Peartree Hill Solar Farm

Environmental Statement Addendum Revision 3

Application Document Ref: EN010157/APP/8.2
September 2025

Figure 1.2: Land Areas and Cable Routes Plan with Field Numbering System

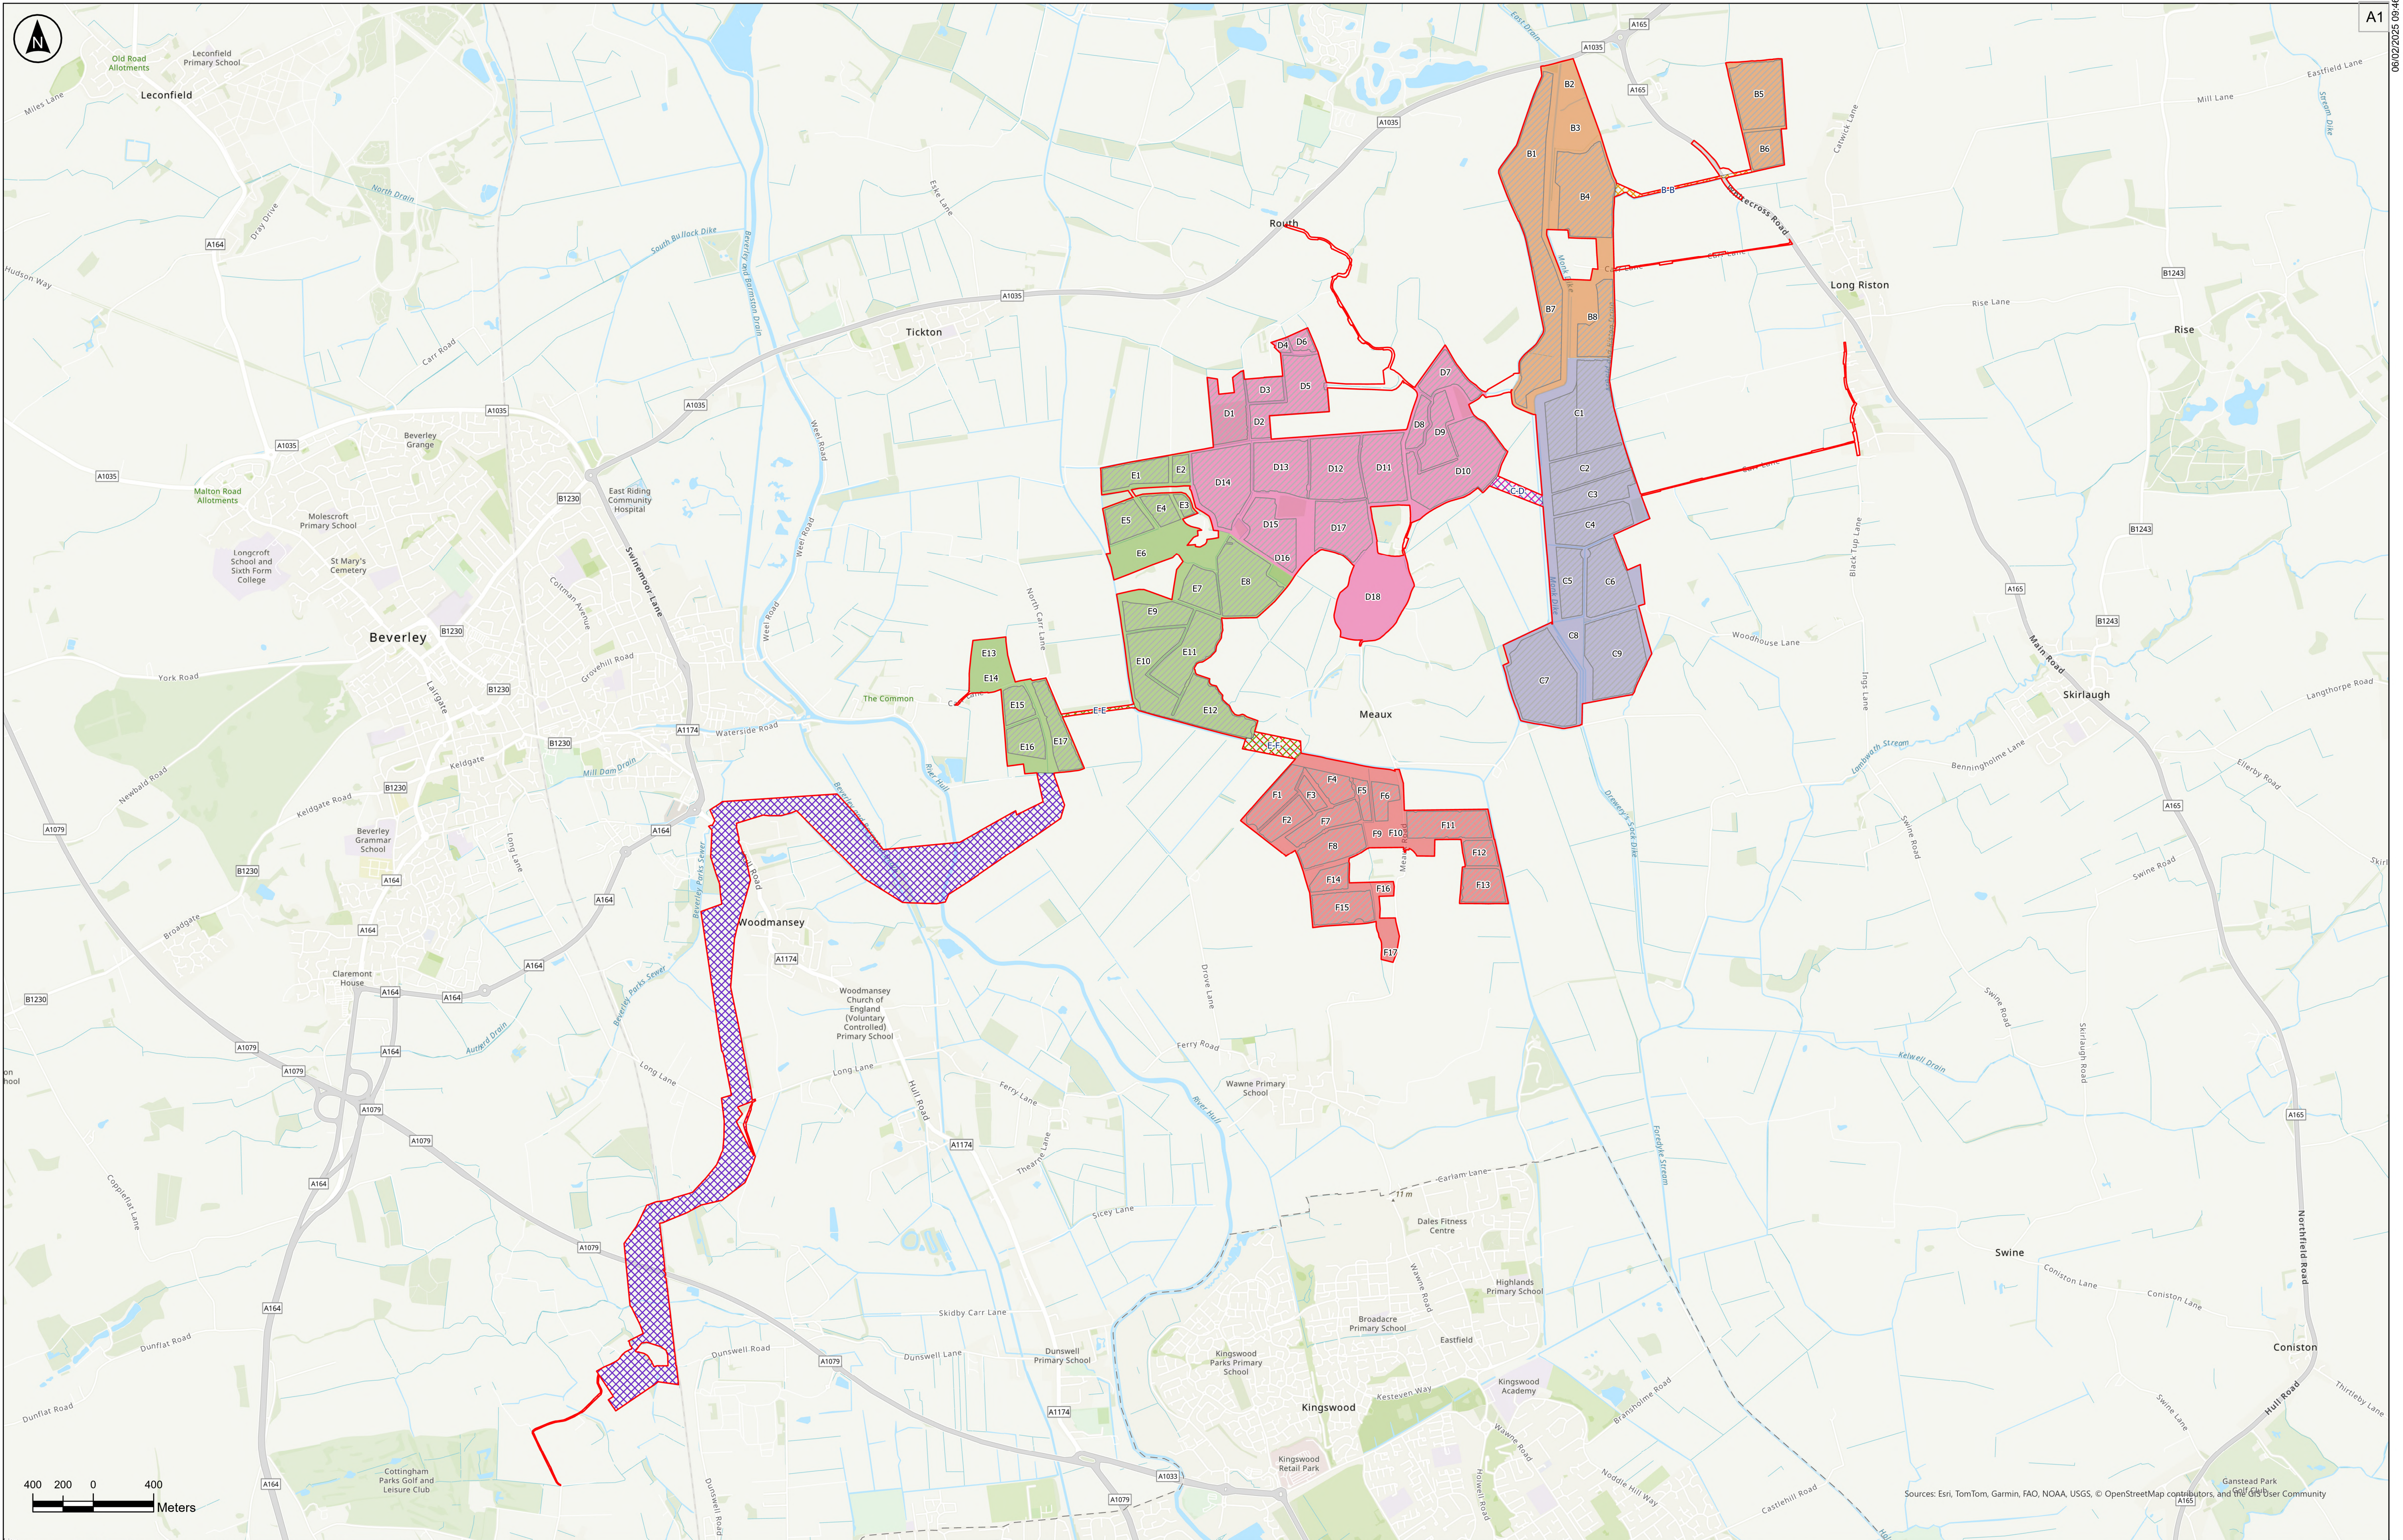
| Document reference | Reason for amendment | ES Amendment July 2025 |
|--|---|--|
| ES Volume 3, Figure 1.2: Land Areas and Cable Routes Plan with Field Numbering System [APP-053] | Figure 1.2 requires amendment to reflect the removal of a section of solar array from Land Area B as part of change/correction 1. | |

| Document reference | Reason for amendment | ES Amendment July 2025 |
|---|---|------------------------|
| | Figure 1.2 also requires amendment to reflect the removal of plots 10-4, 10-5 and 10-6 as part of change/correction 2. | |

#### Figure 6.1: Demolition (During Decommissioning Phase)/ Earthworks/ Construction Activities Study Areas

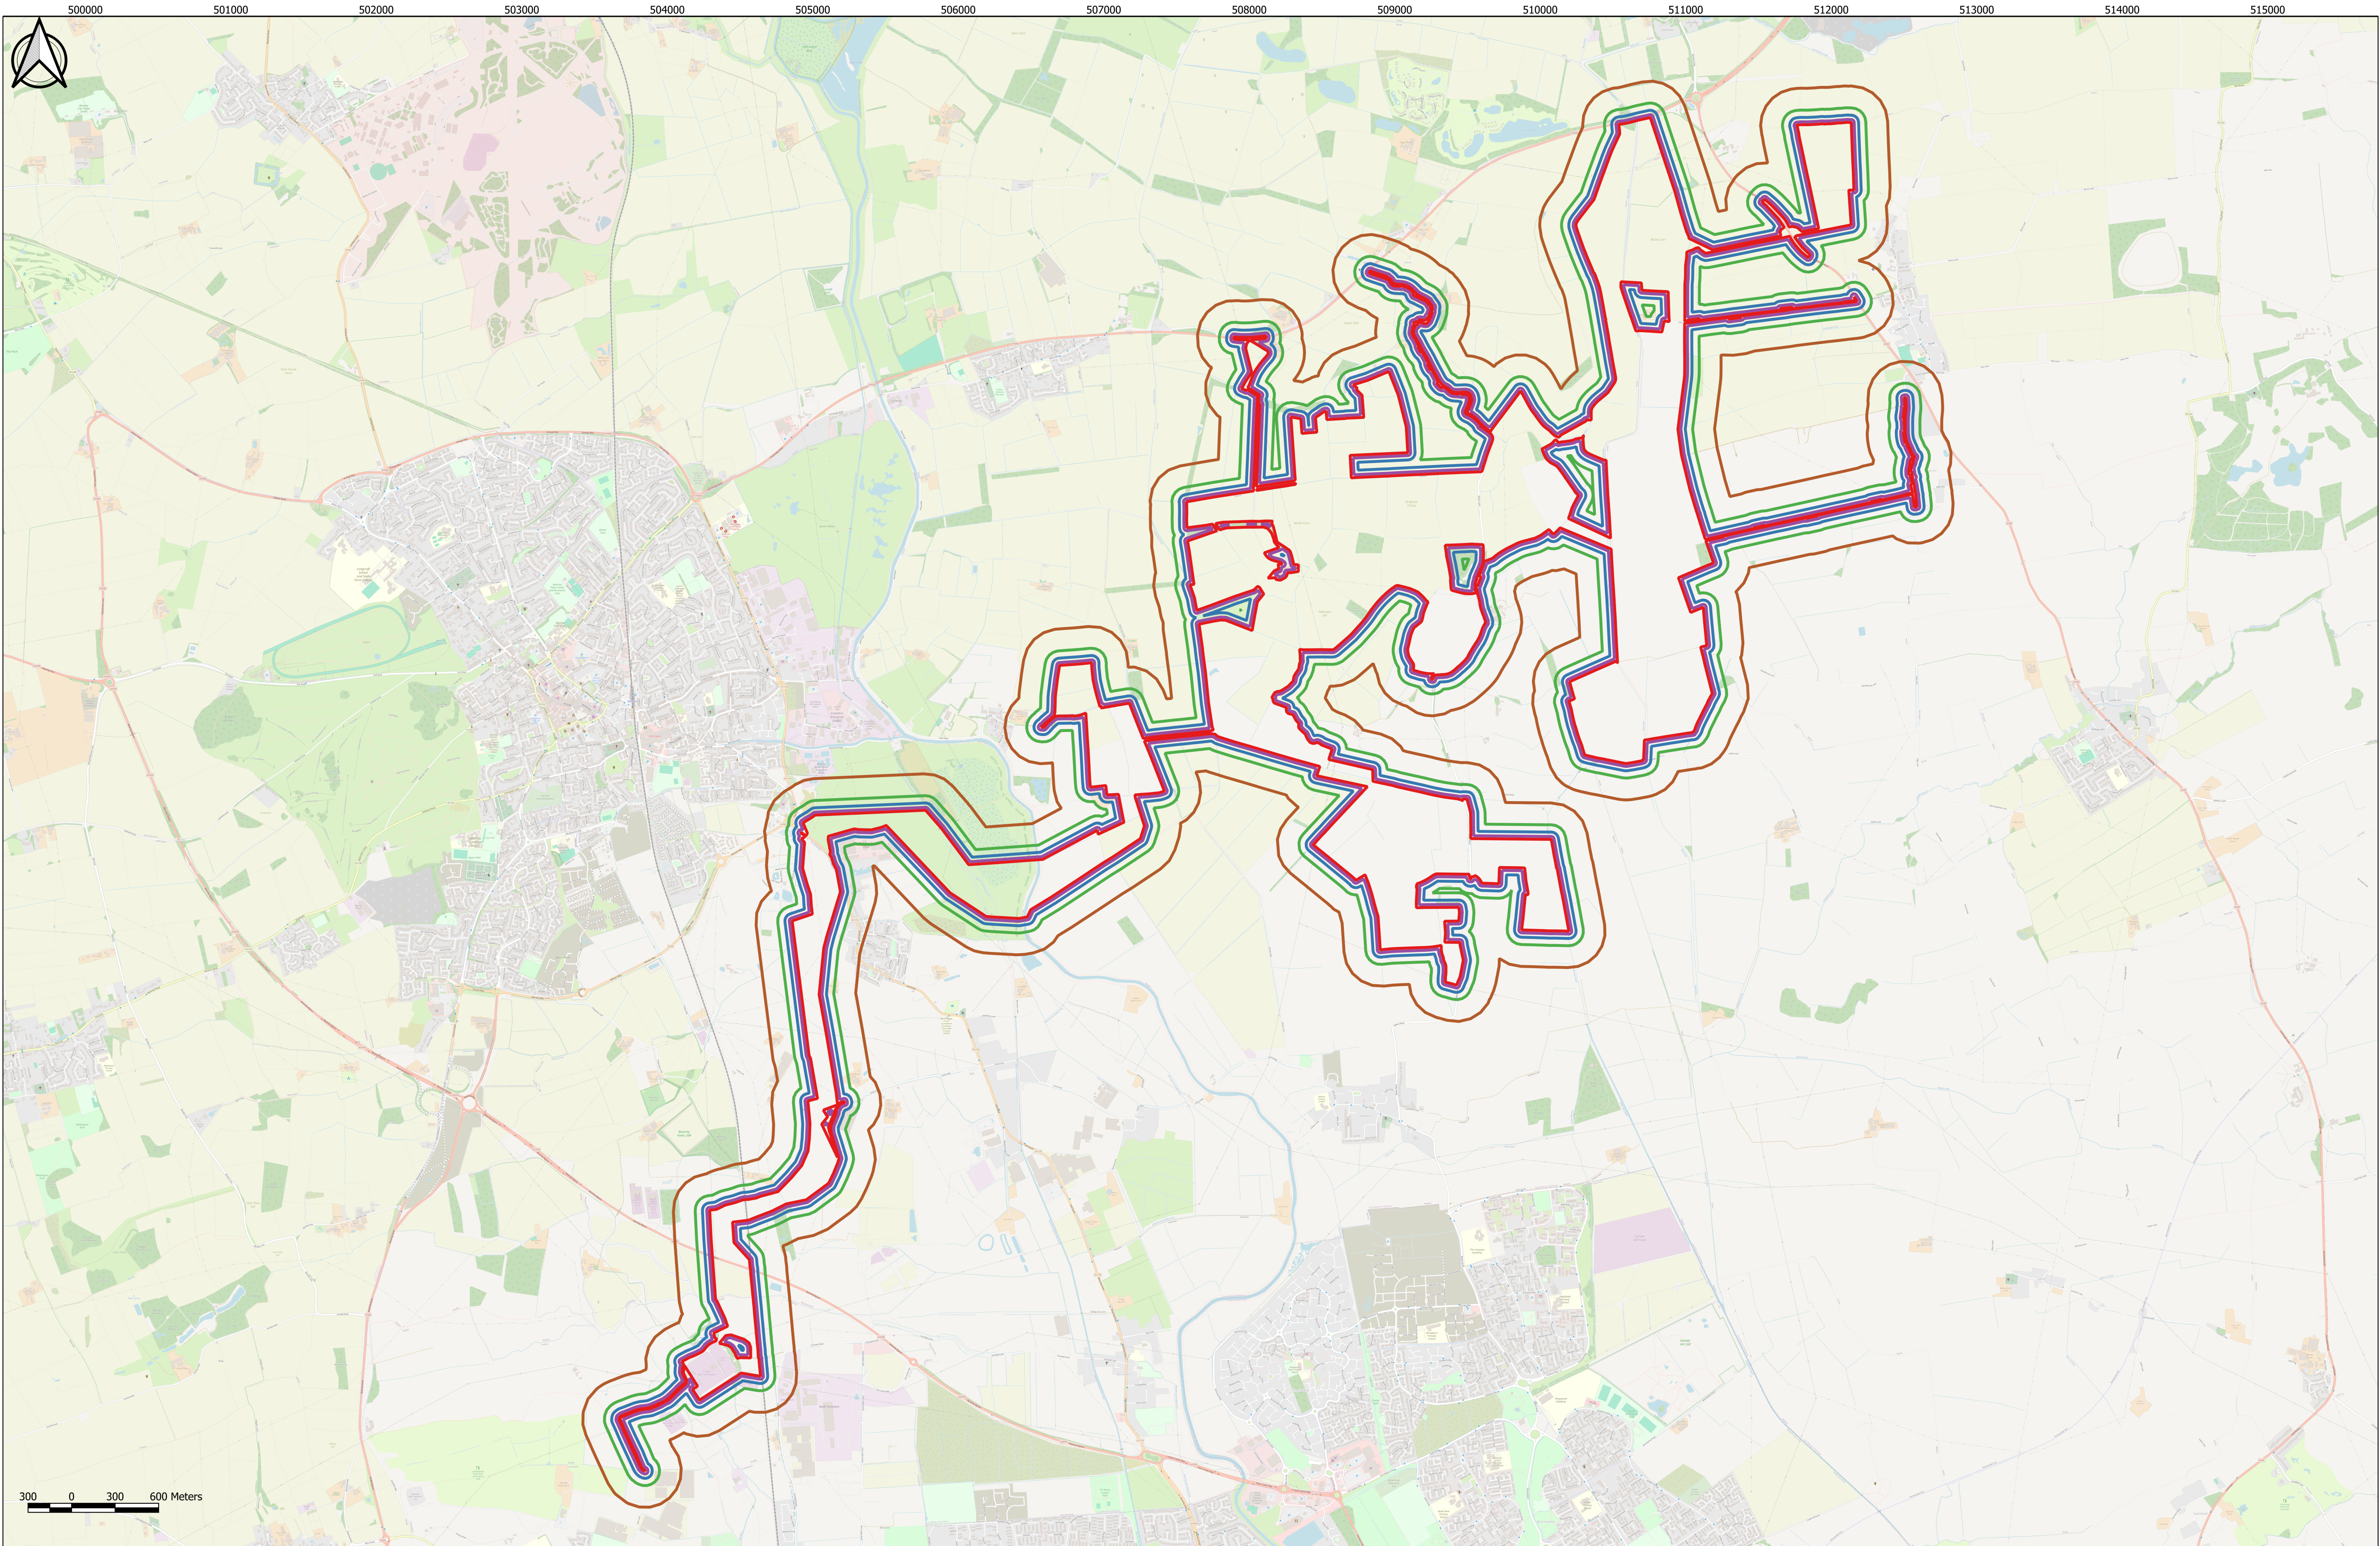
| Document reference | Reason for amendment | ES Amendment July 2025 |
|--|--|------------------------|
| ES Volume 3, Figure 6.1: Demolition (During Decommissioning Phase)/ Earthworks/ Construction Activities Study Areas [APP-063] | Figure 6.1 requires amendment to reflect the removal of plots 10-4, 10-5 and 10-6 as part of change/correction 2. | |
